COUNTY COUNCIL'S RESPONSE TO CONSULTATION ON THE FOLLOWING DEVELOPMENT PROPOSAL

Application No: 18/00193/REM-3

Proposal: Reserved matters application to 14/02156/OUT - for appearance, landscaping and layout (including the layout of the internal access roads, footpaths and cycleways) for 37 dwellings.

Location: Land South Of Cotefield Business Park, Oxford Road, Bodicote.

Road 4
Horiz. 1:500 Vert. 1:50

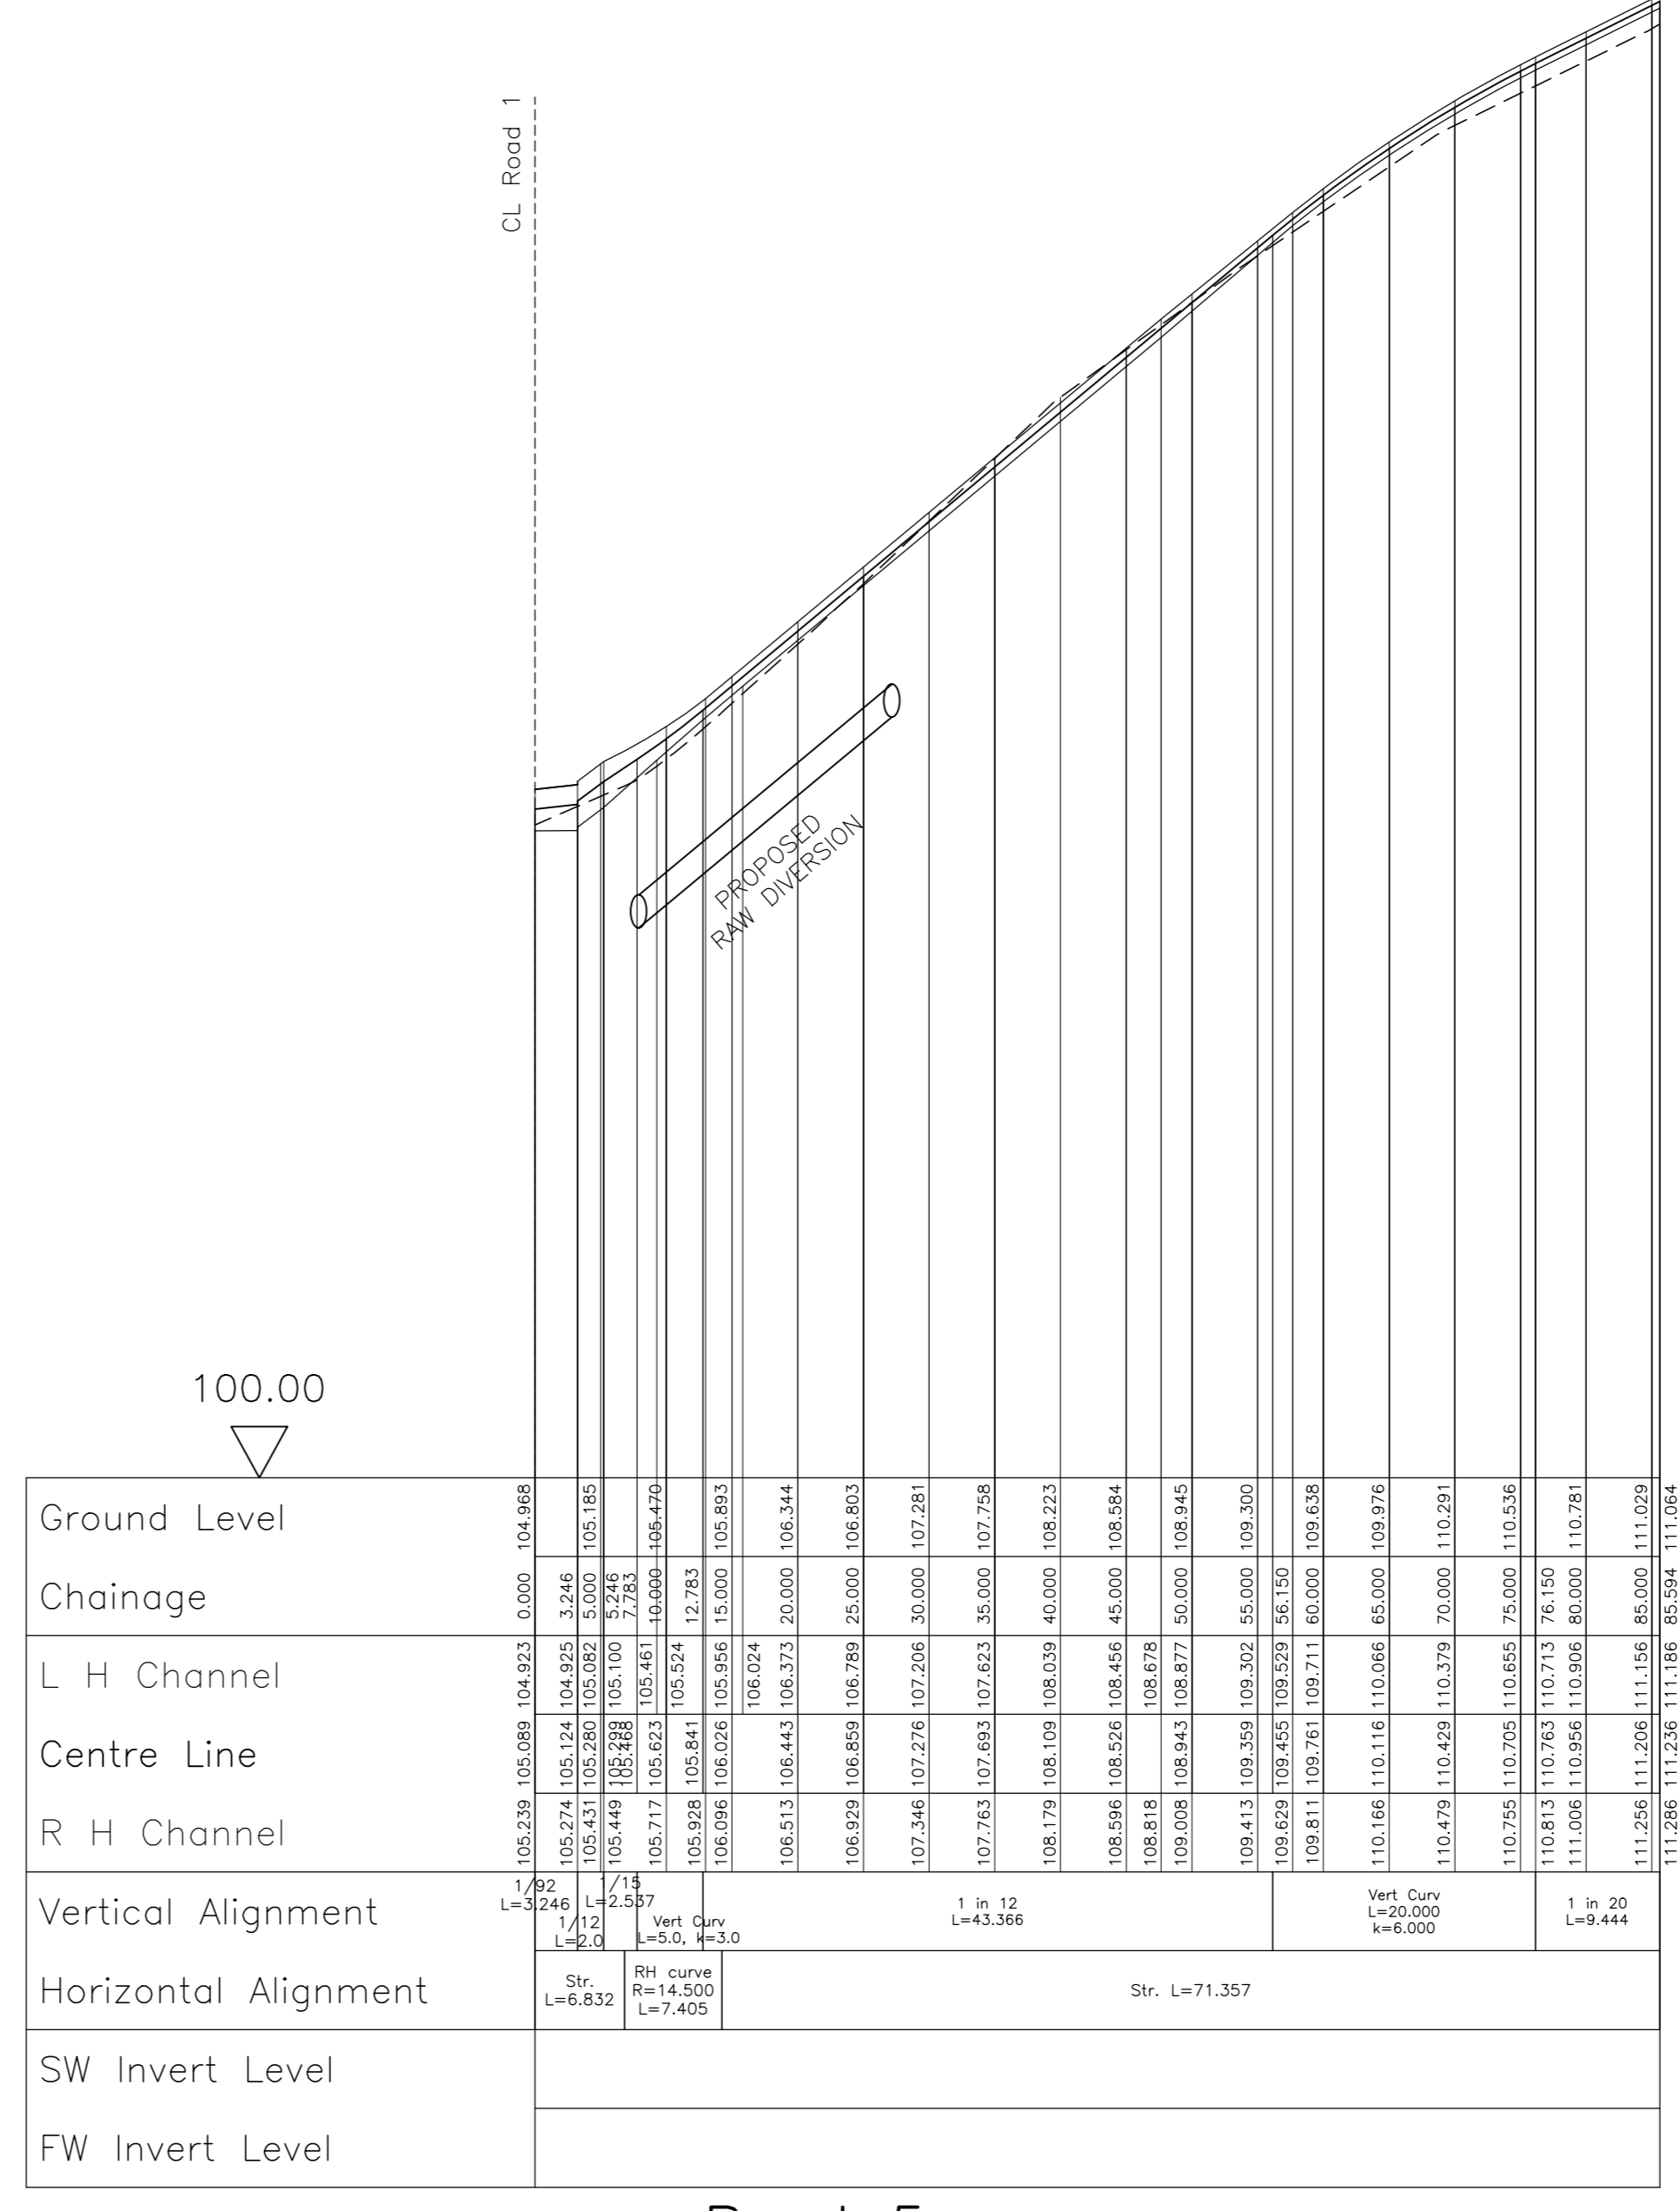
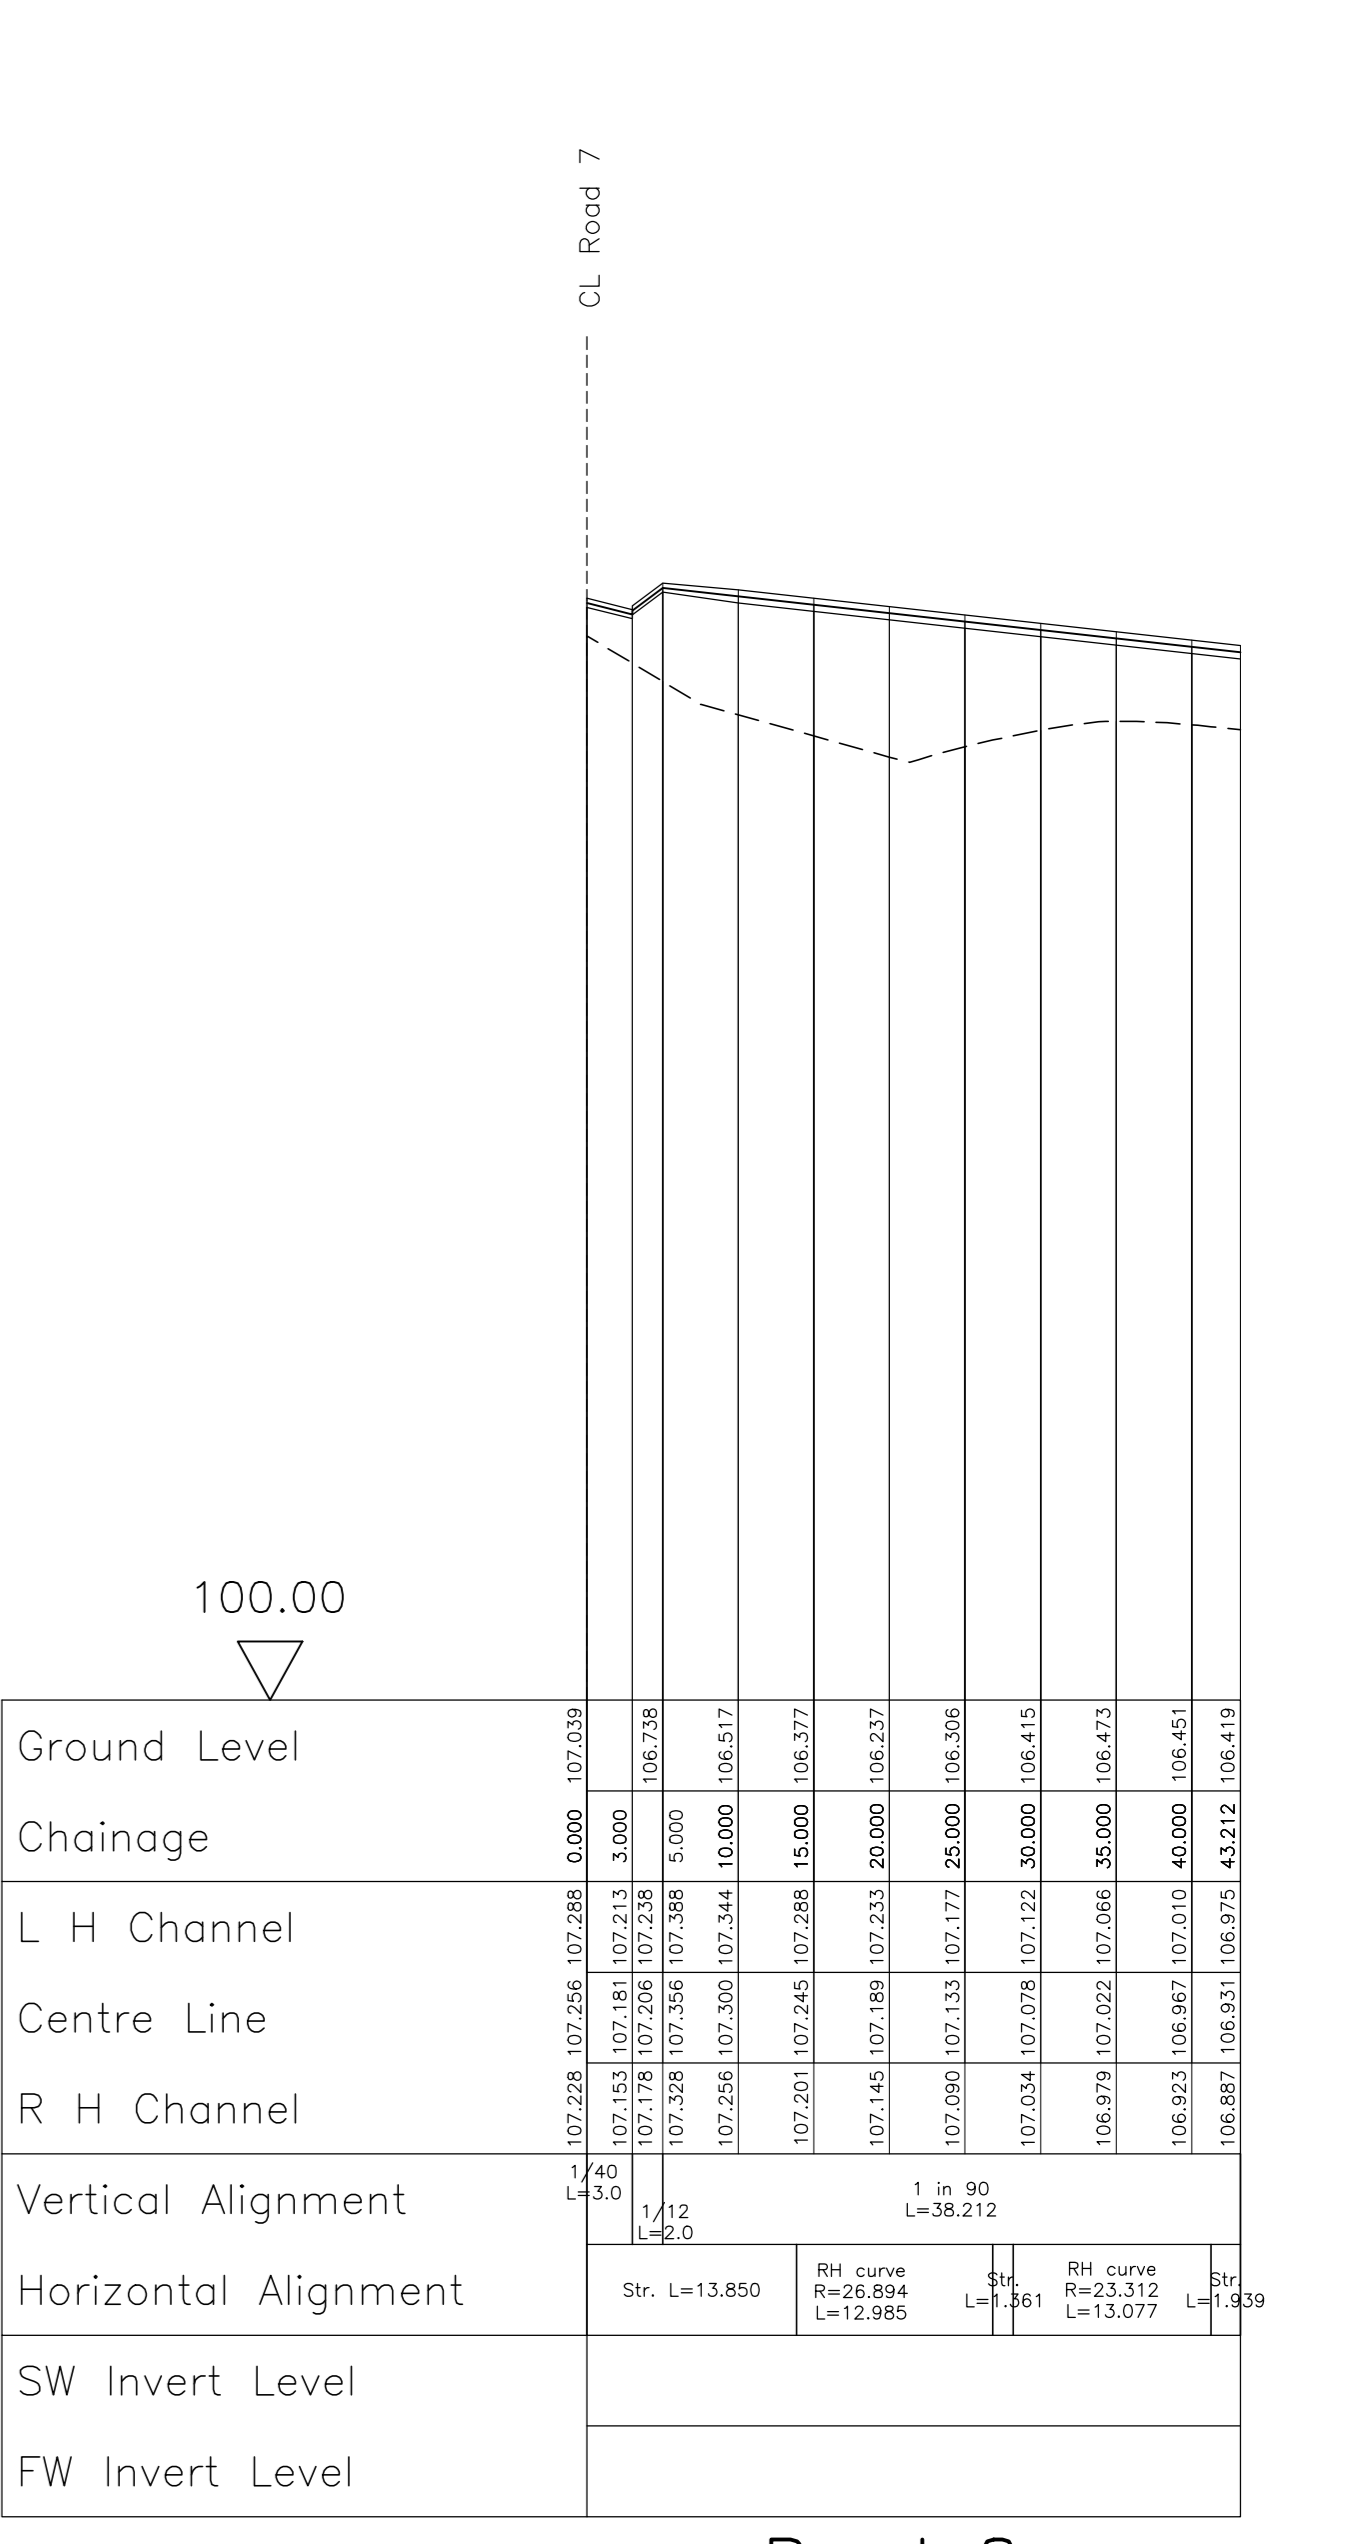
Regarding the proposed levels, 1:12 is the absolute maximum gradient that the Local Highway Authority will accept, and this only over very short lengths of road where it is unavoidable. If the gradient is 1:12 or above over longer stretches of road, this will inhibit access to parts of the development for the elderly, disabled people, and parents with small children or who move pushchairs. Therefore, this is contrary to paragraph 32 of the NPPF and I recommend objection on these grounds.
